Reference: #13S1213000

18 April 2016

**RE: 1 CARRINGTON STREET, SYDNEY
CARPARK ASSESSMENT FOR CC DOCUMENTATION**

Car Park Ramping Swept Path Assessments

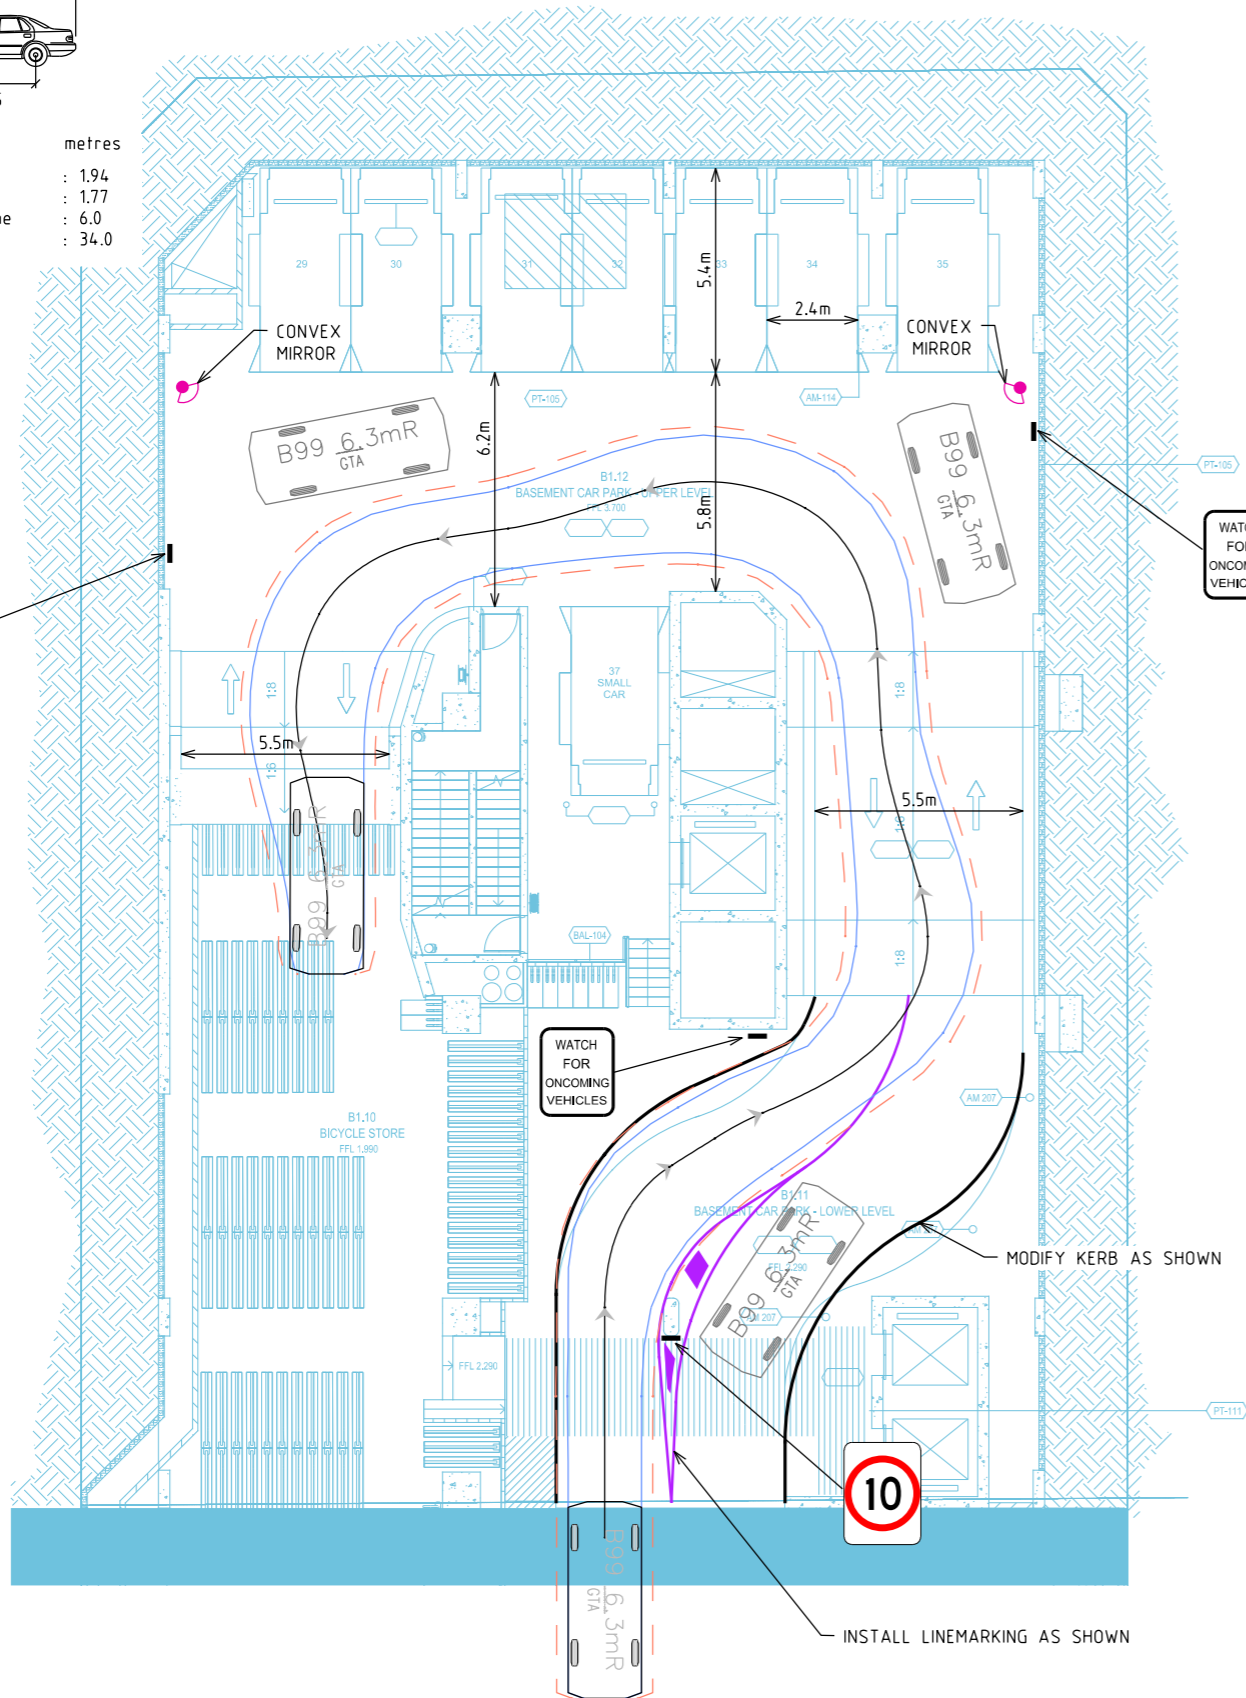
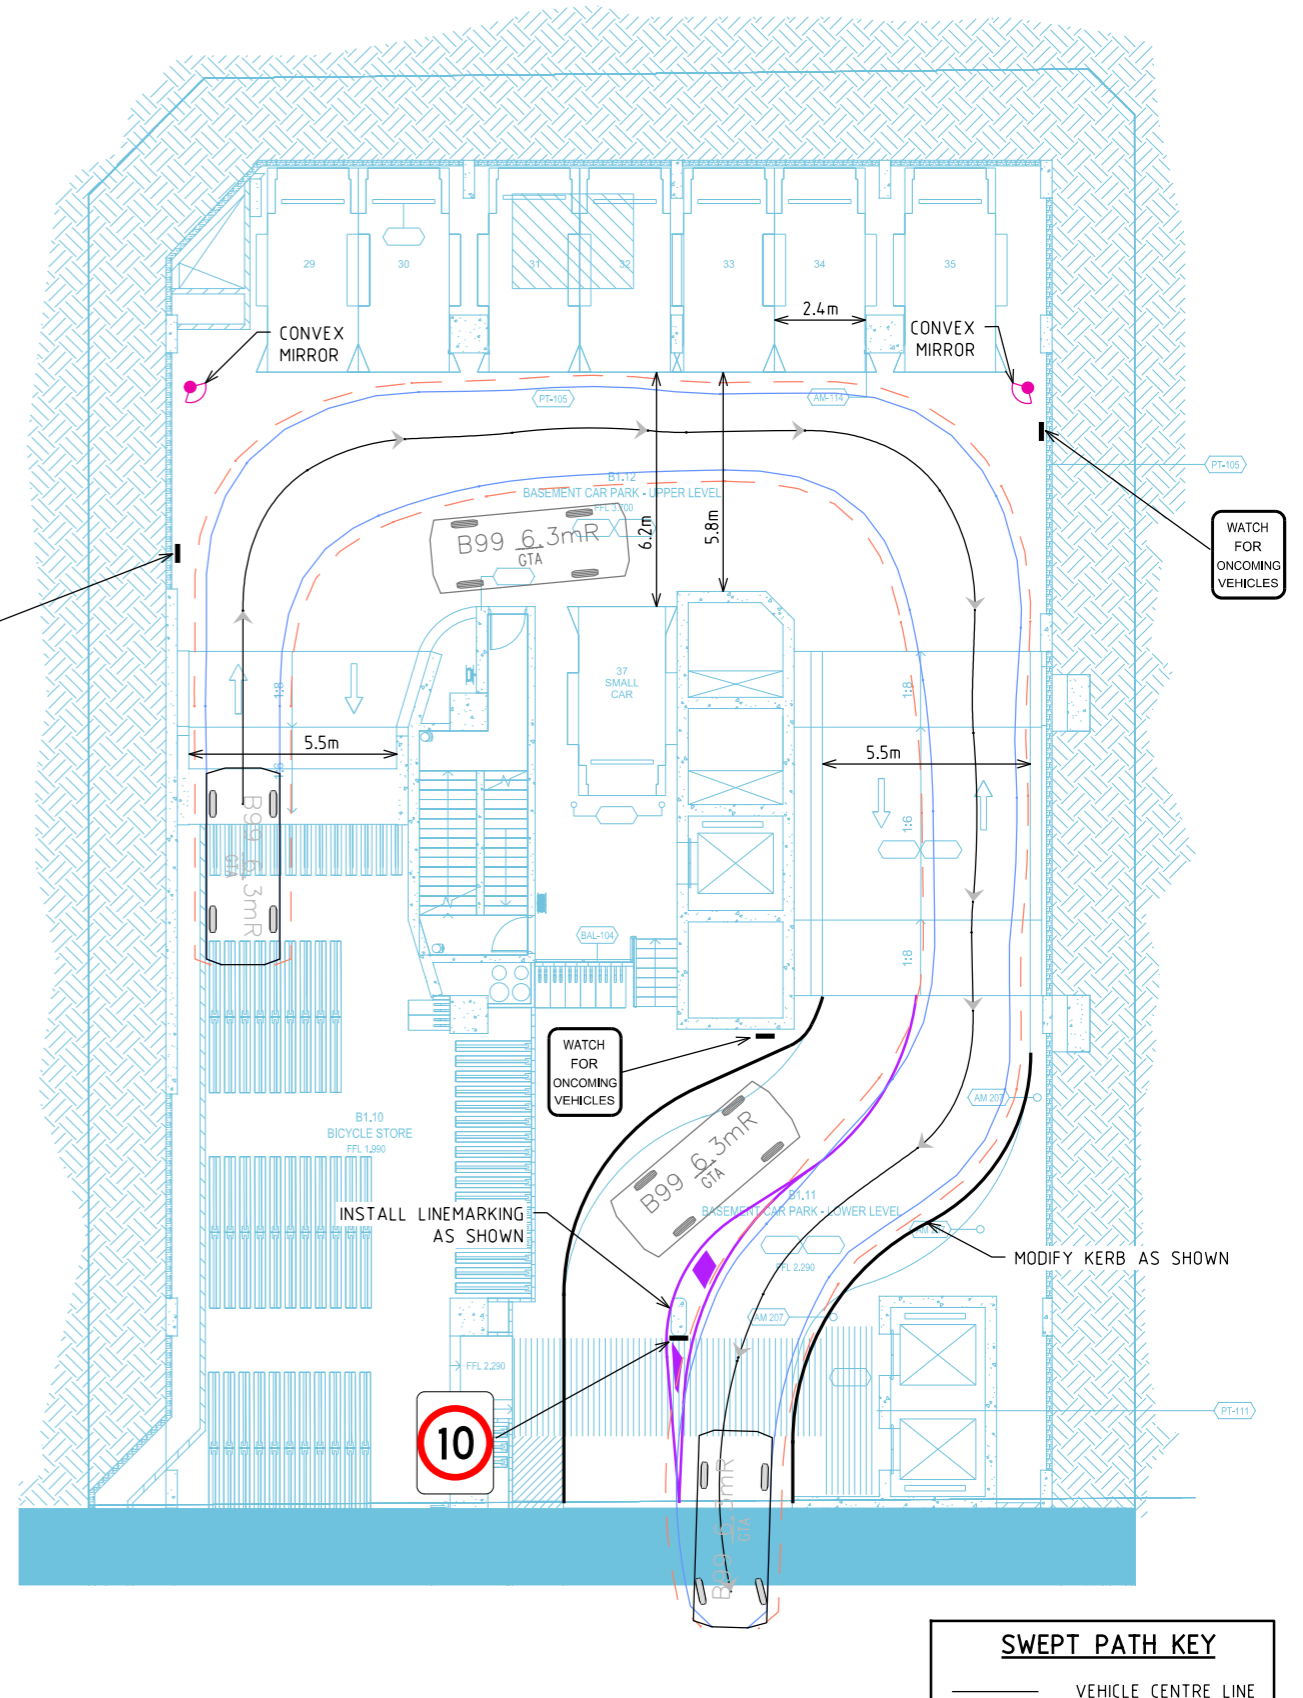
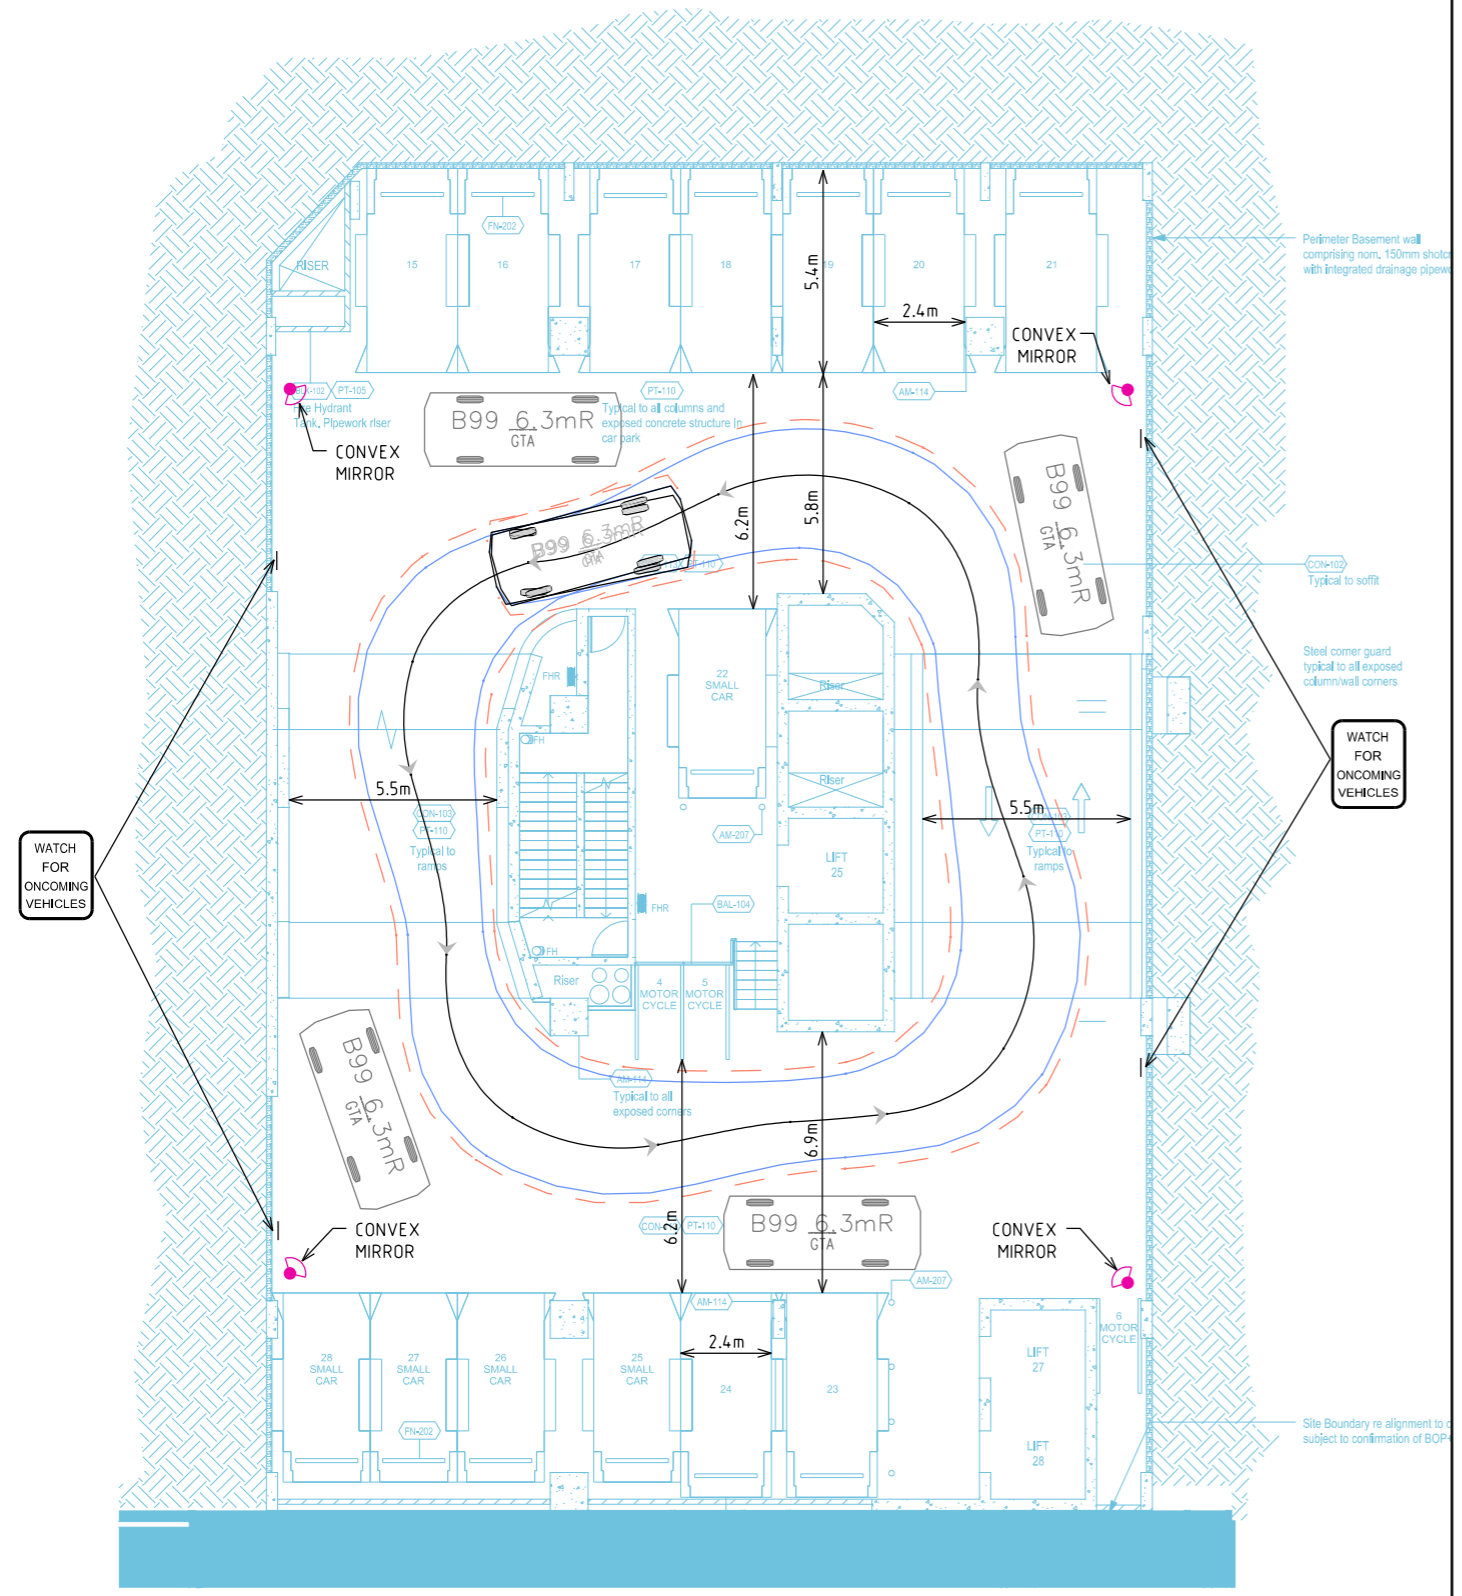
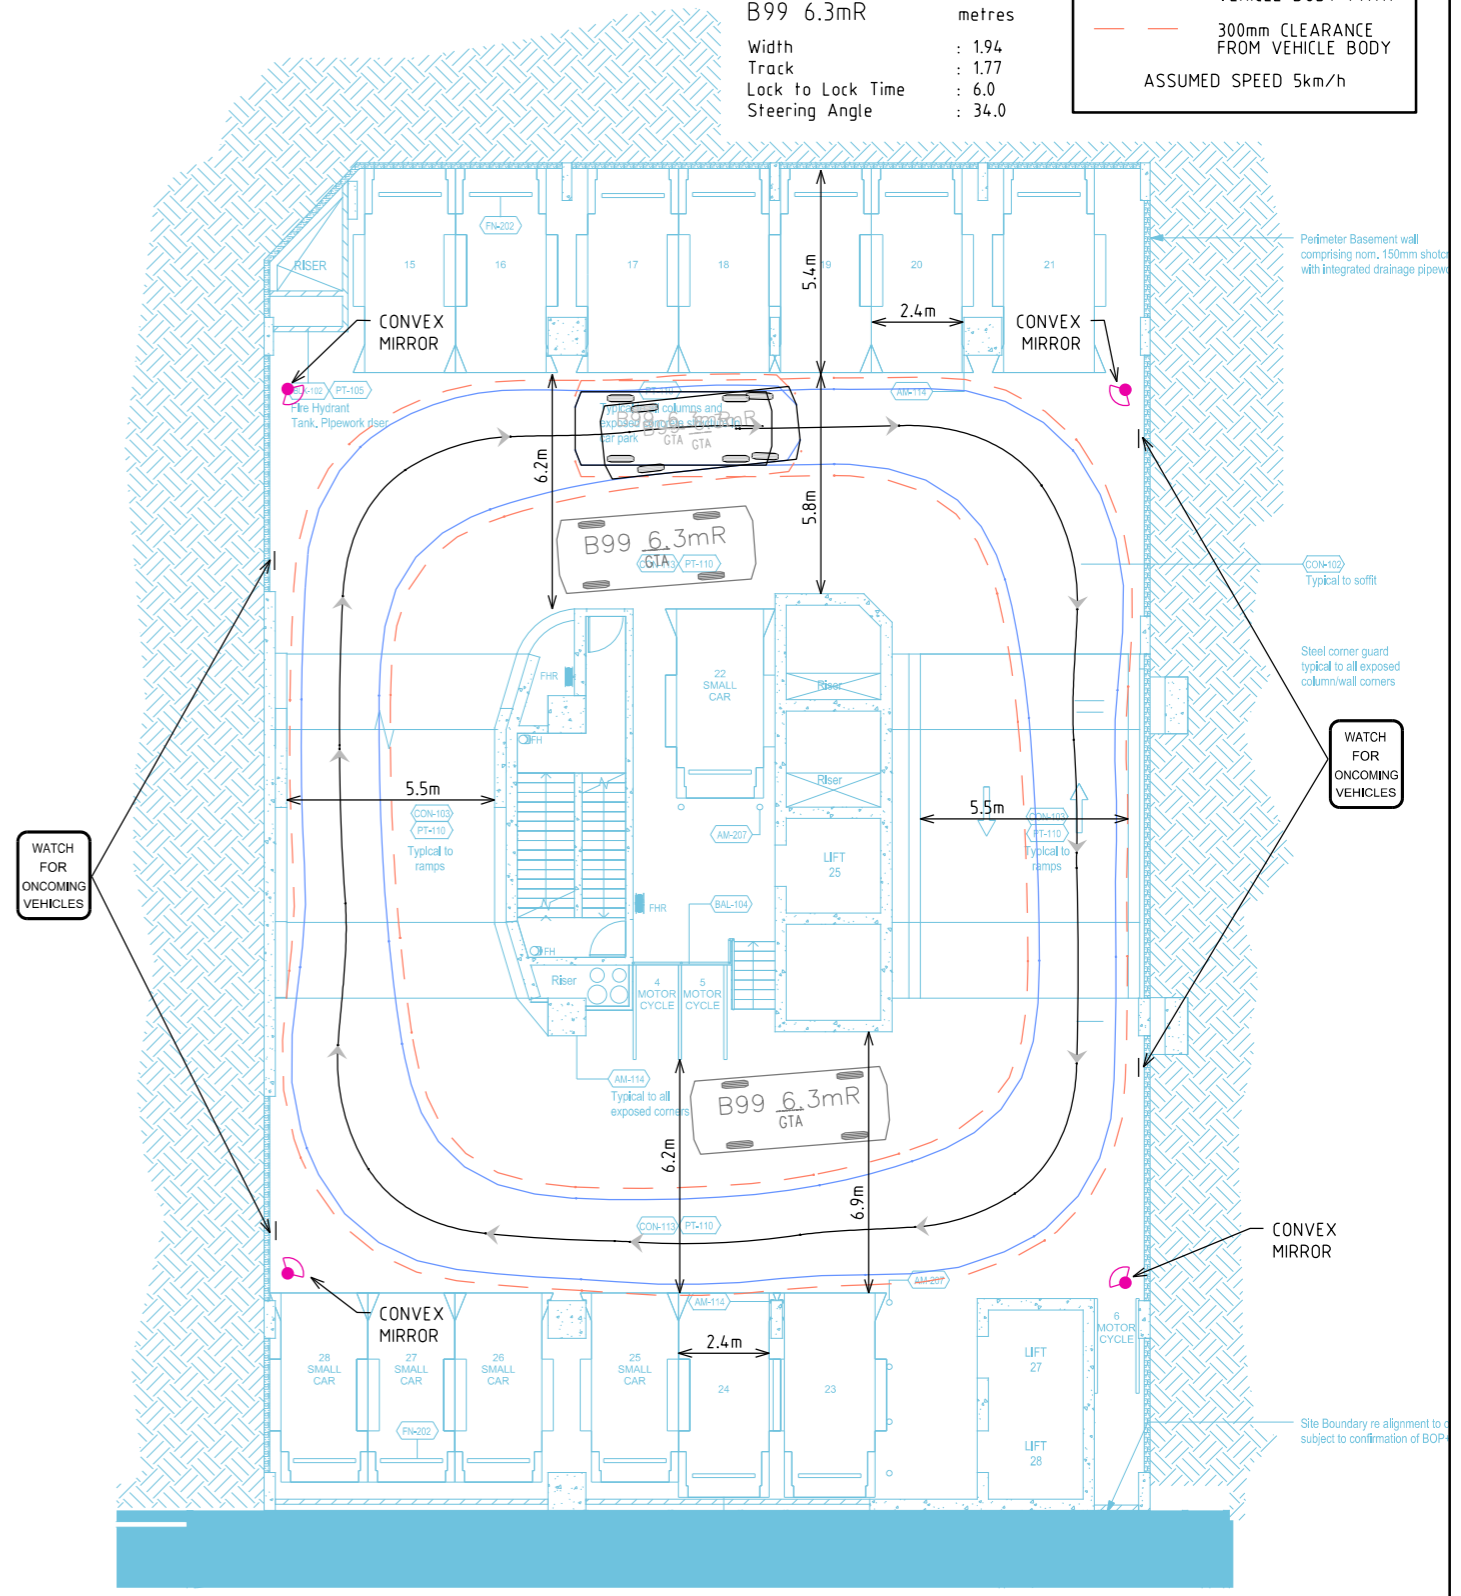
With respect to the car park within the Shell House Building, it is noted that the intersections between ramps and aisles do not accommodate the passing of a B99 and a B85, but rather simply a B99 to travel through the intersection and pass another nearby vehicle which would need to wait for the other vehicle to pass.

Albeit a technical non-compliance, the impact of two cars not being able to simultaneously pass each other is, in our view, minor, noting:

- The traffic volumes within the site are likely to be very low (for 89 car spaces within the basement, it is approximated that the car park would generate approximately 50 car movements in any peak hour).
- The probability of two vehicles needing to pass at any point within the car park, let alone one of the corners, is expected to be low given that the majority of cars will be entering and exiting the site during the AM and PM peak hour.
- The physical constraints of the site itself are such that it would be impractical to design for such an infrequent worst case scenario (noting that many building in such locations would feature this non-compliance)

In practice, the non-compliance is also unlikely to detrimentally impact the circulation of cars within the car park, or the safety of such movements, given that adequate space has been provided to allow cars to pass each other at suitable locations.

Moreover, it is also noted that this non-compliance was discussed at length within the GTA letter report (dated 9/11/15) submitted for the Section 96 Application, with swept paths from that letter presented below for reference. These swept paths show that vehicles will be able to pass each other at suitable locations near the internal intersections. GTA is not aware of any concerns with respect to this layout as submitted and approved but nevertheless note that the currently worded Consent Condition require a far more onerous design outcome.

In light of the identified issue, it is proposed that any conflicting vehicle movements, albeit minimum due to the unidirectional nature of their use, be managed via:

- i At the entry point to the Shell House Building carpark, entering vehicles are informed by signage to:
 - I. turn on head lights
 - II. give way to exiting vehicles
 - III. proceed down the ramp slowly
- ii Once circulating within the carpark ramps, entering vehicles have right of way over exiting vehicles. In the unlikely event that a conflicting (entering) vehicle approaches the ramp, an exiting vehicle is to manoeuvre into a position to enable the other vehicle to pass. These locations are shown in Figure 1,
- iii The provision of other signage and convex mirrors as shown in Figure 1.
